Footing Plan for 2-Car Garage
58 Plainfield Lane
Lillington, N.C. 27546
6/2/2025

From: Richard Peppe <pepperwj@aol.com>
Sent: Thursday, June 19, 2025 10:05 AM
To: Michelle F. Myatt
Cc: Dick Peppe; Maggie Peppe
Subject: Re: Business License Number for Site Built Sheds
Attachments: Owner Affidavit.pdf

Sorry for the delayed answer to the engineers questions concerning the garage bill. Been out of town the last week due to real estate transactions.

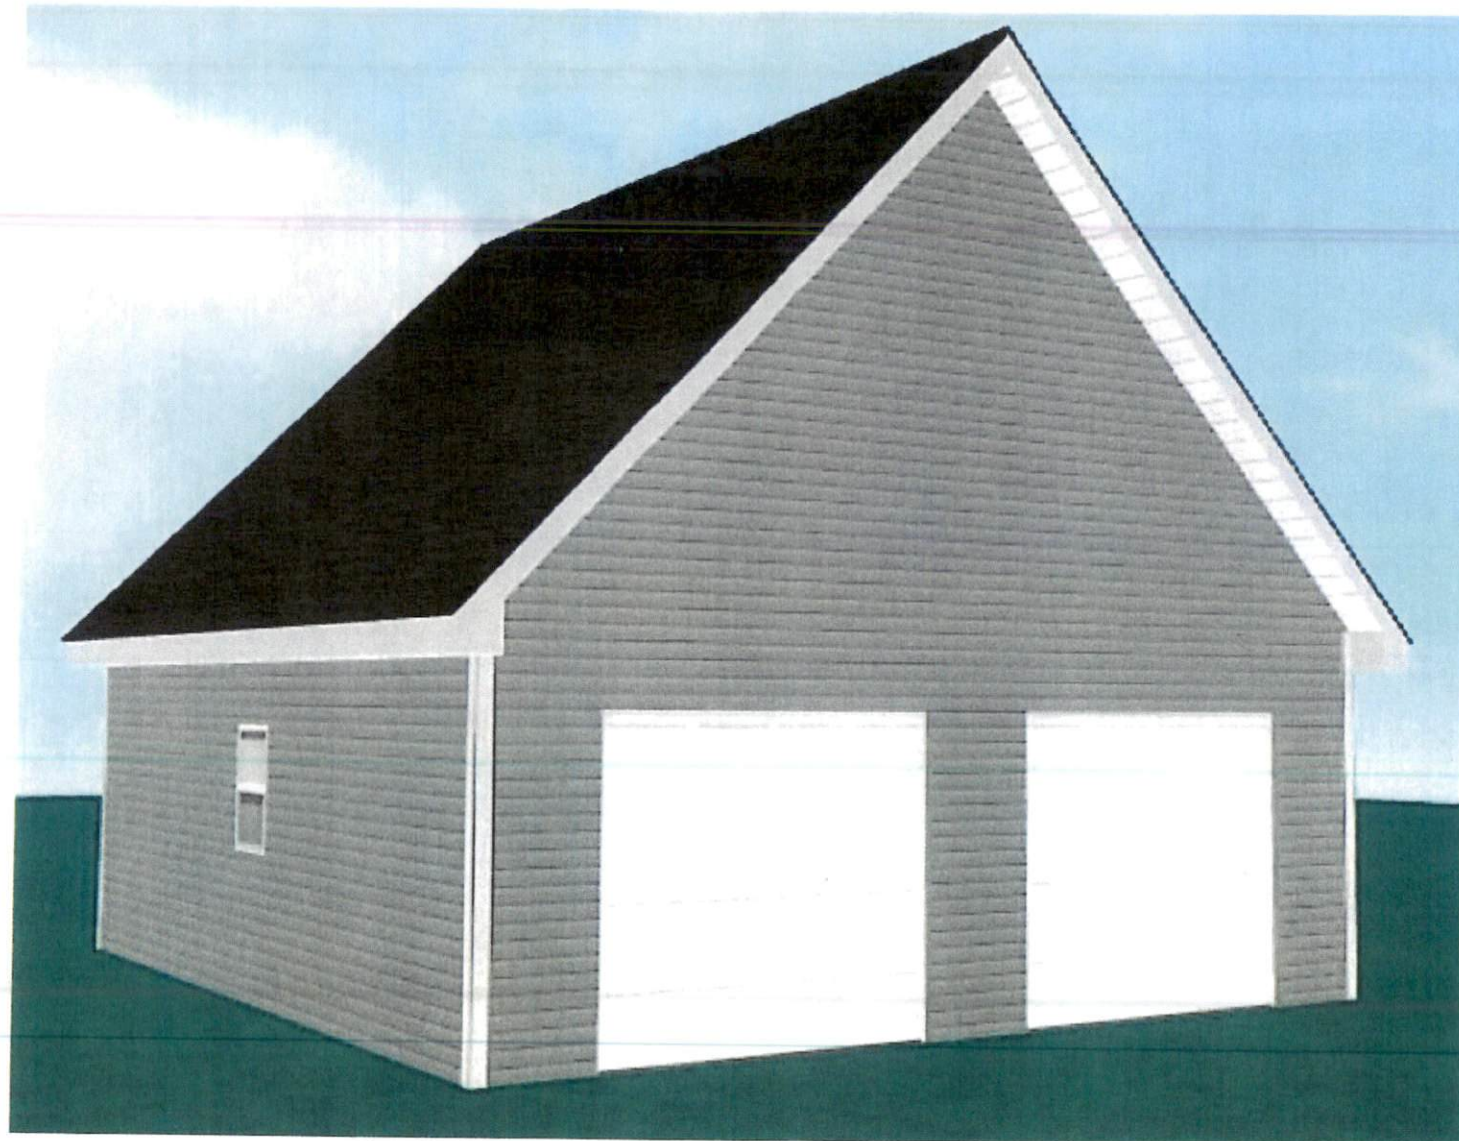
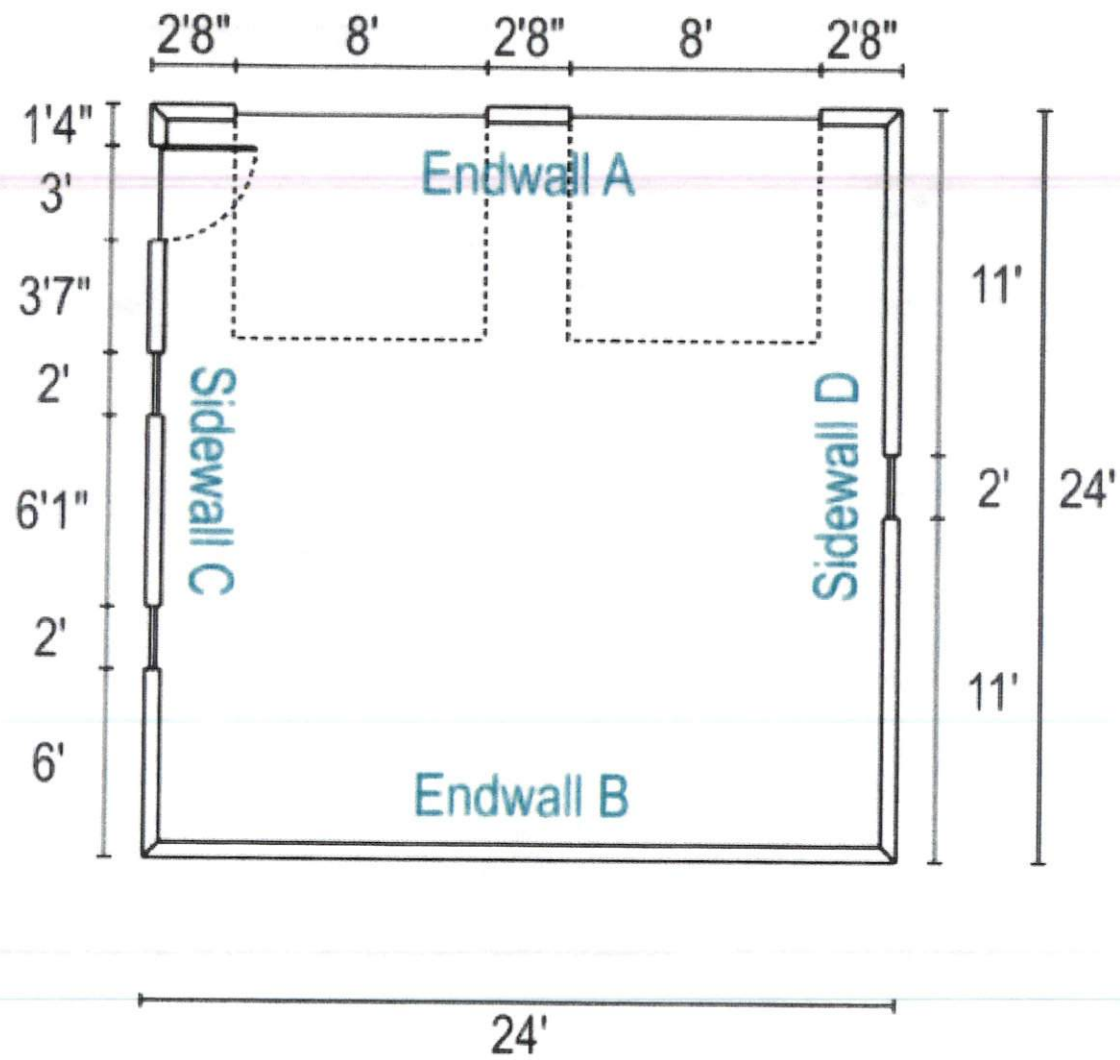
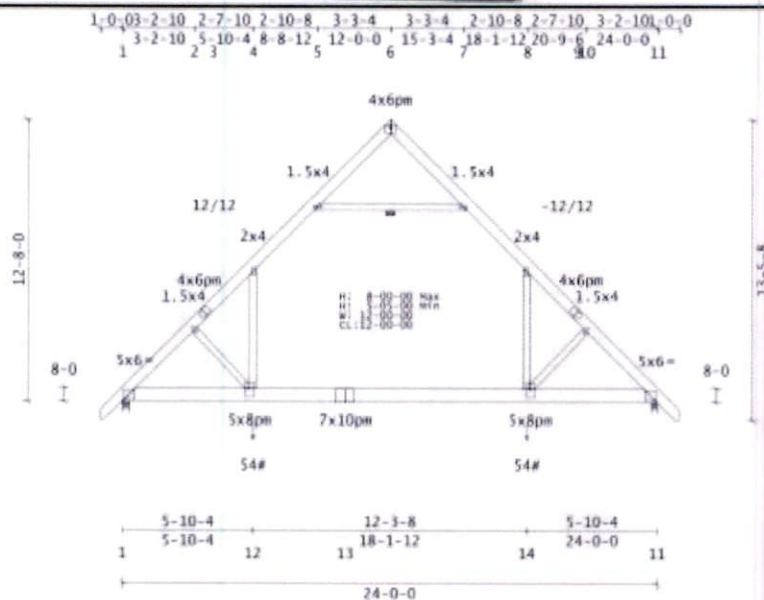
1. What is going to be stored on the second floor space of the garage?

2. Access to the second floor will be a stair way = Three rails installed under each step with a hand rail. It will be located in the back of the garage-Approximately 16 steps. No windows will be installed on the second floor since it is for storage only. Electrical lighting will be installed later in the year once the garage is completed and that will require another work permit.

3. Per our plans the walls meeting up with the roof will be 8 feet tall, 16 inches on center. The soffits will extend on the exterior 12 inches. Eventually gutters will be installed later in the year.

The only things that will be stored on the second floor will be my wife's Christmas decorations. These are very light containers ranging from Christmas, easter, July 4th, etc.
